FREEDOM SPRINGS
734 WESTERN DRIVE
COLORADO SPRINGS, EL PASO COUNTY,
COLORADO, 80915

PME UTILITY PLAN
PME-100

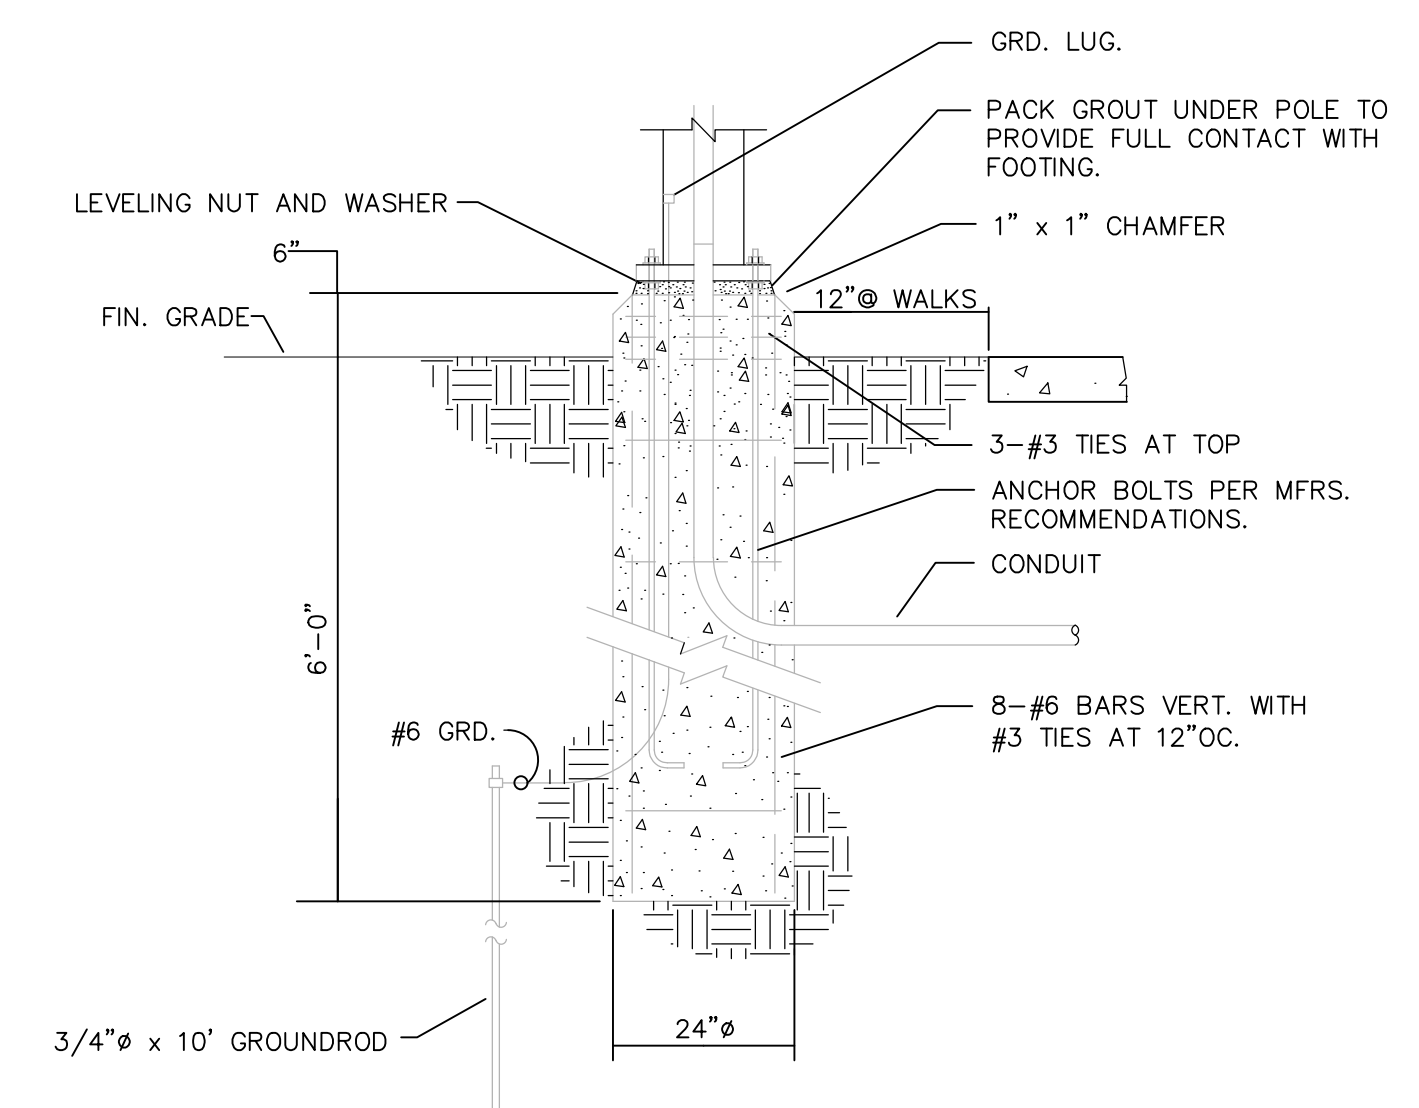
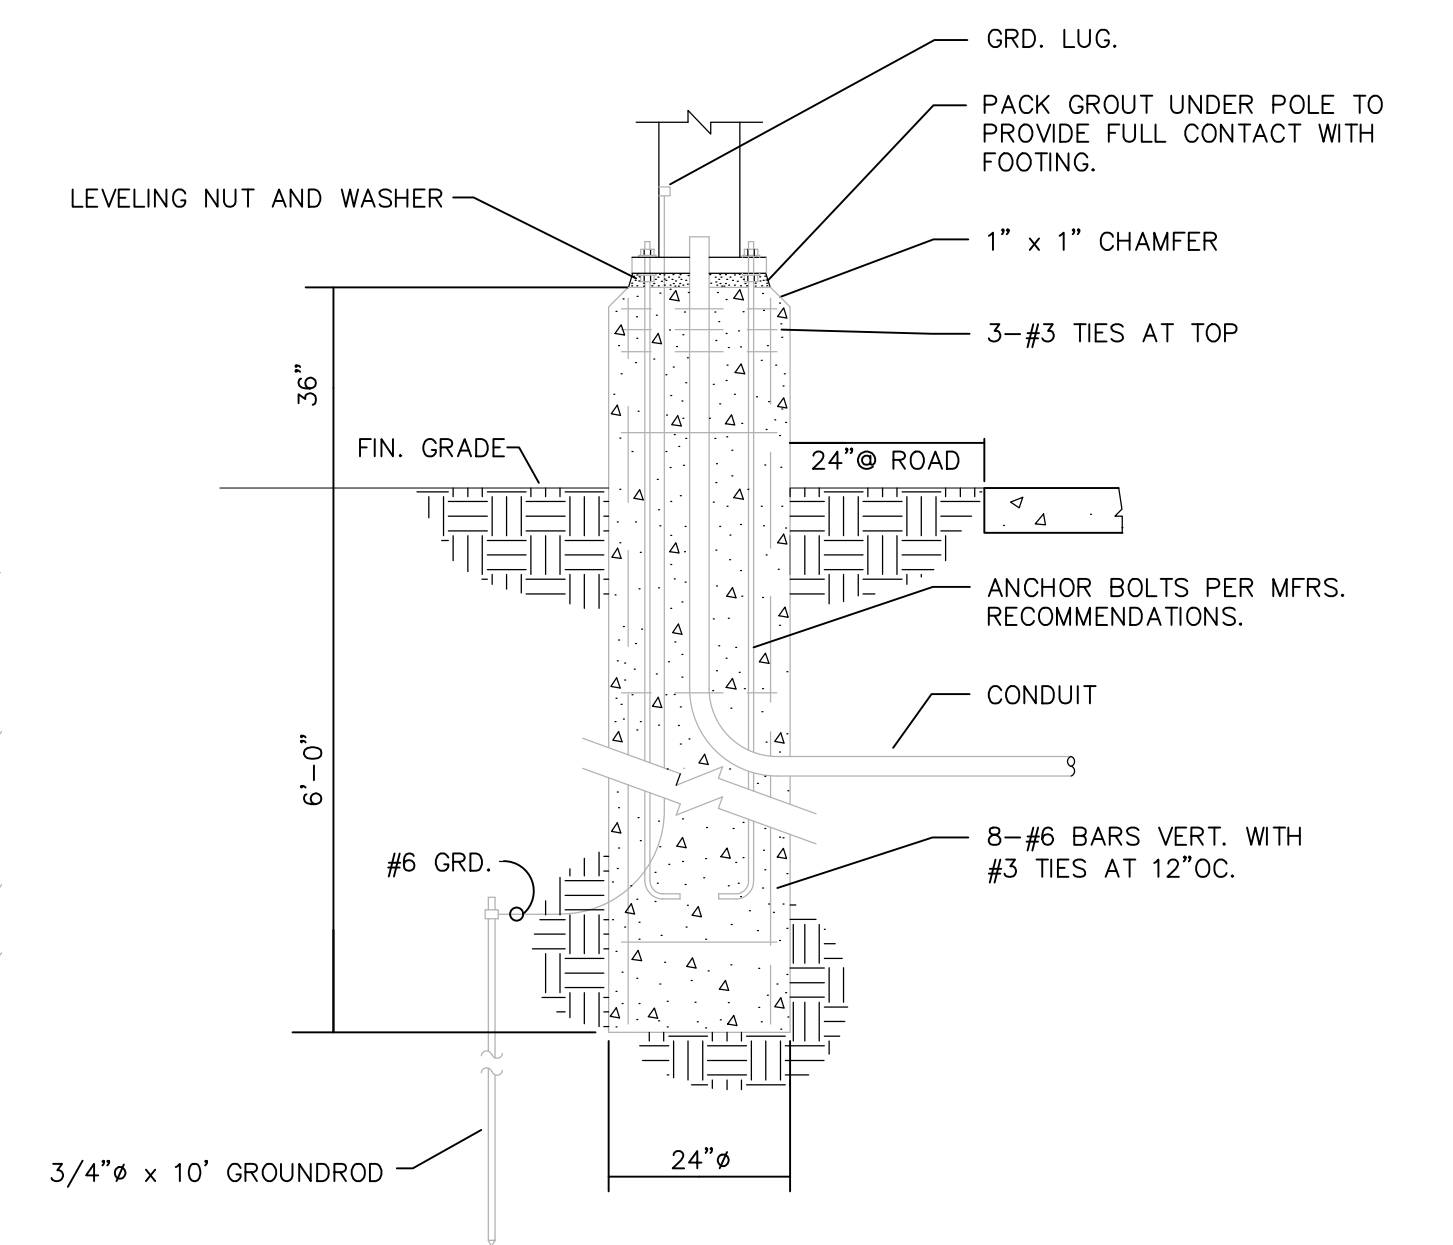
Detail sheet of light pole height to verify it meets standards in the LDC

Needs to be a full photometric to determine scale at boundary line.
